OFFICIAL NOTICE OF DECISION

CITY OF ALBUQUERQUE
PLANNING DEPARTMENT
DEVELOPMENT REVIEW BOARD

13. Project # 1002520

RIO GRANDE ENGINEERING agent(s) for JENNIFER SOULE request(s) the above action(s) for all or a portion of Lot(s) 15 & 16, Tract(s) 2, Block(s) 4, **NORTH ALBUQUERQUE ACRES, UNIT 3**, zoned R-D residential and related uses zone, developing area, located on ALAMEDA BLVD NE, between WYOMING BLVD NE and LOUISIANA BLVD NE containing approximately 2 acre(s). [REF: 04DRB00705] (C-19)

**6' PERIMETER SCREEN WALL DETAIL**  
NTB

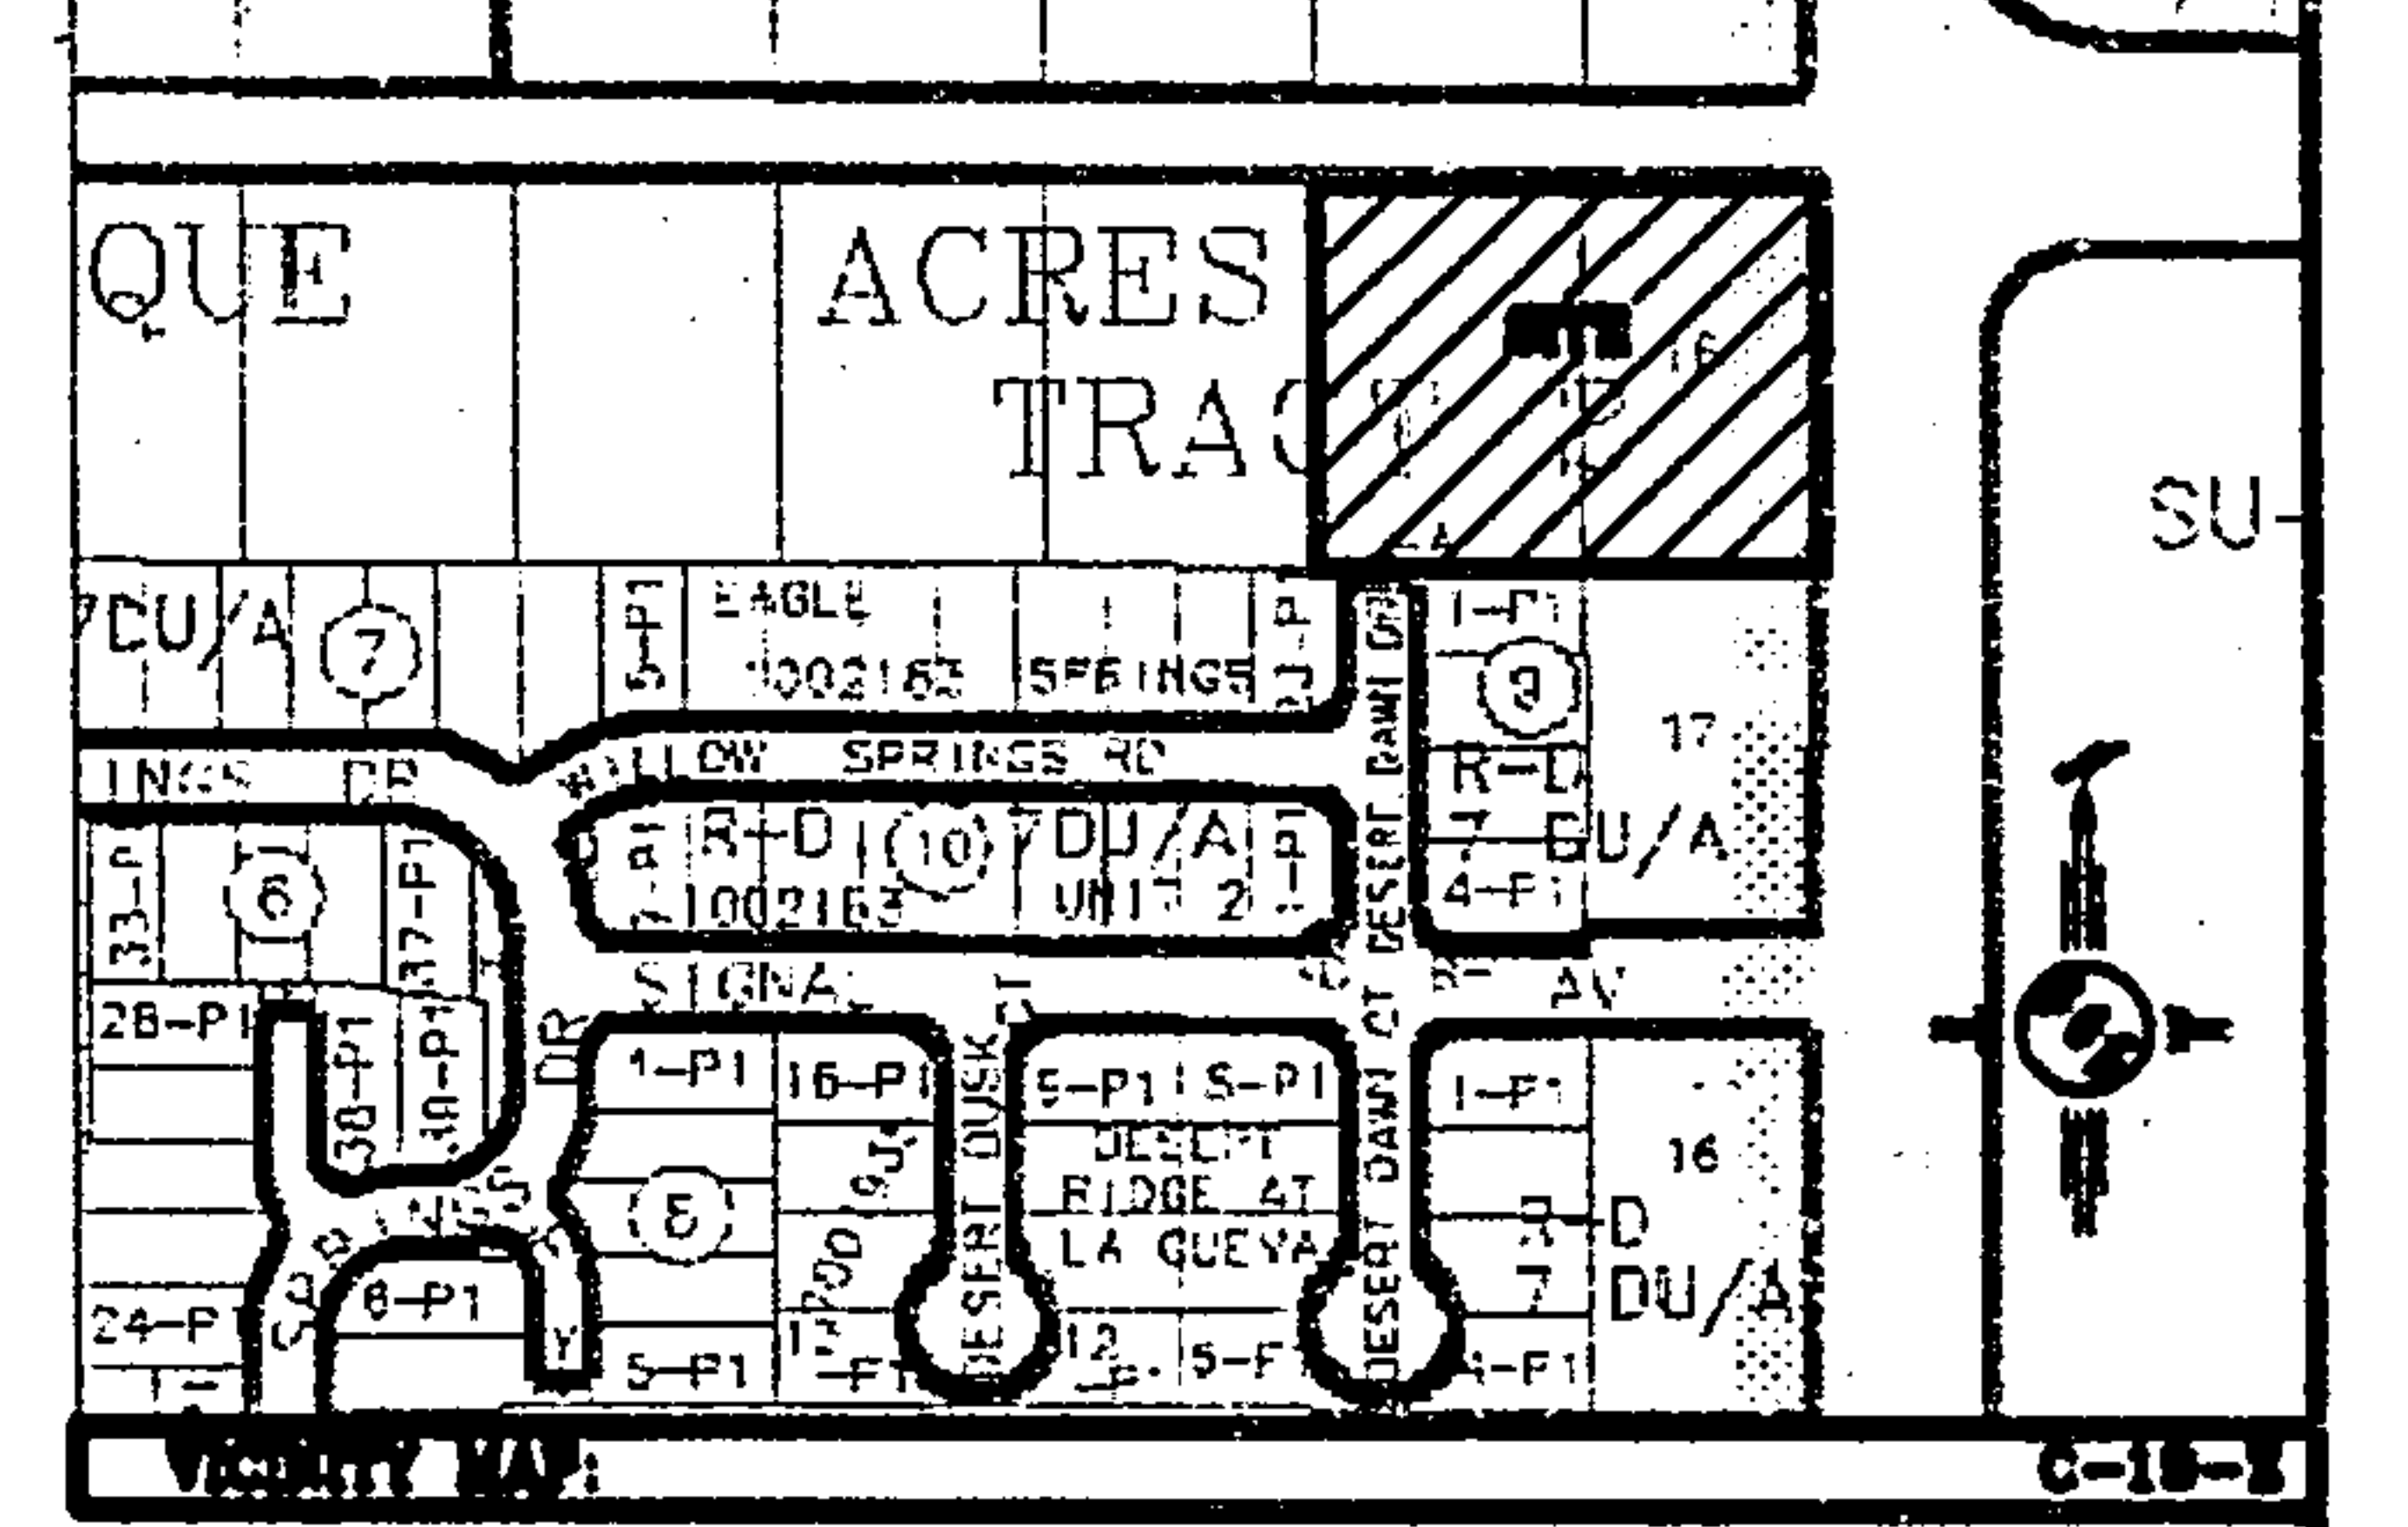
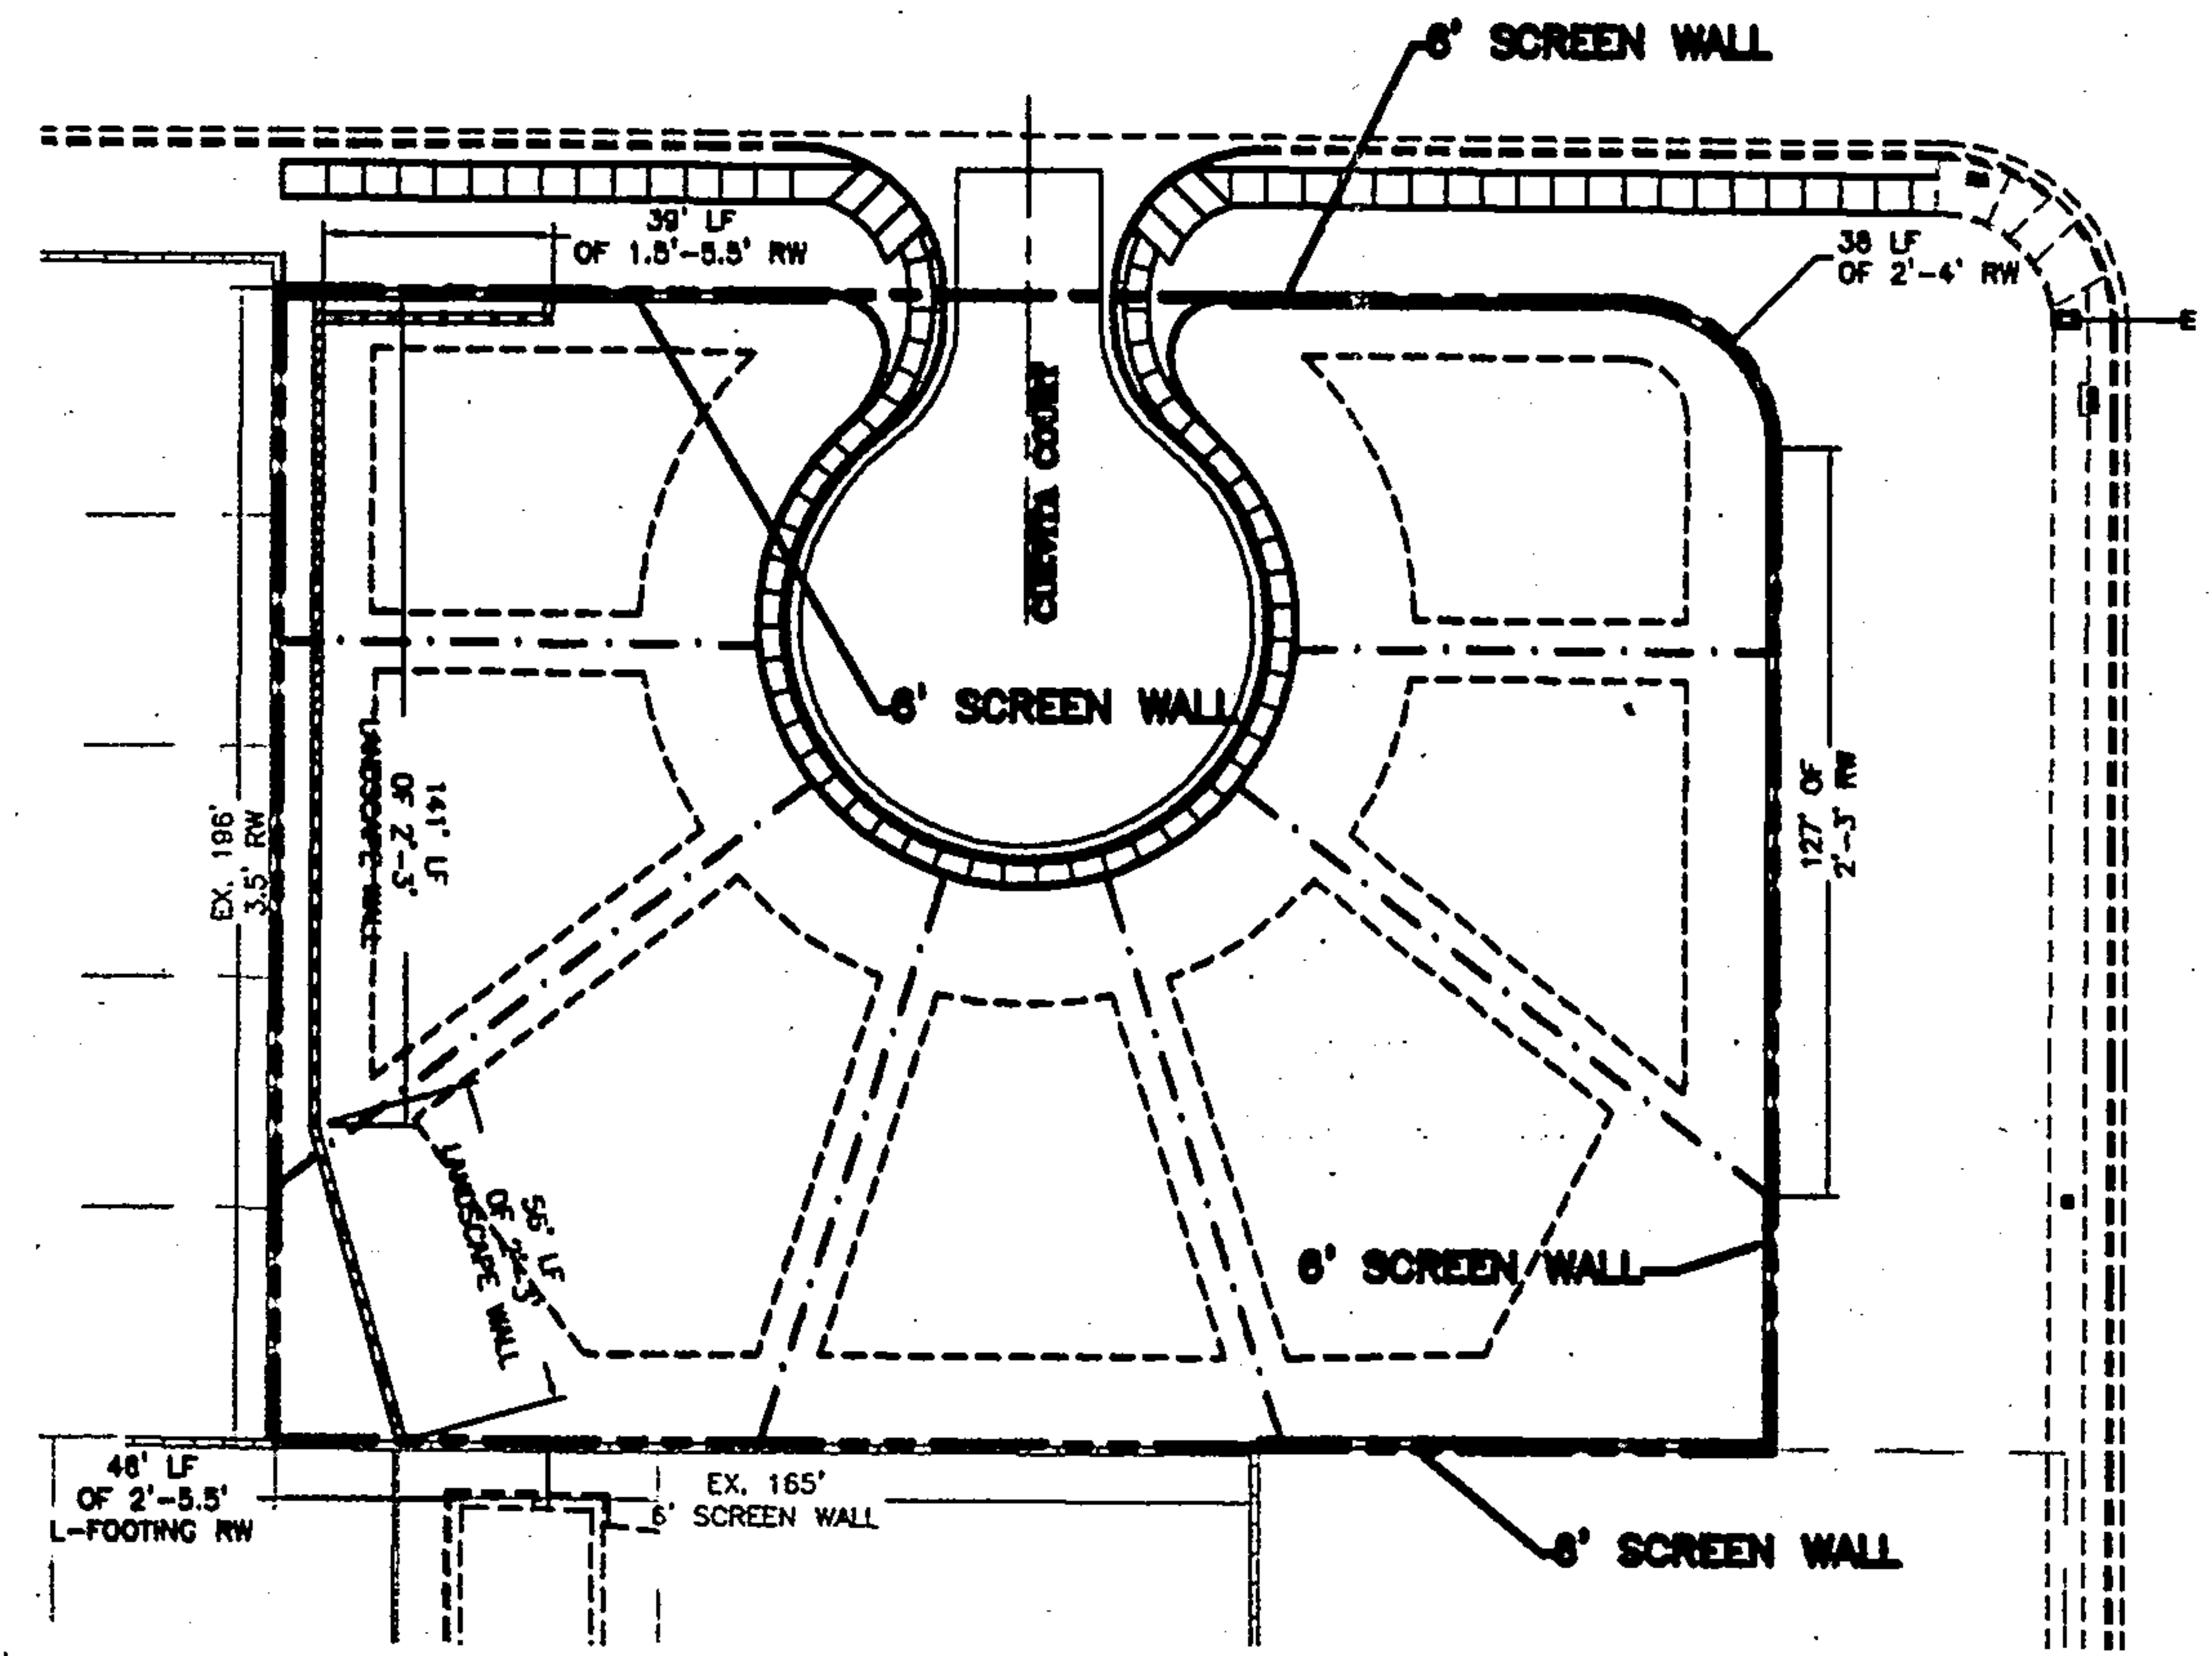
Wall design submittal shall be revised to meet Zone Code requirements.
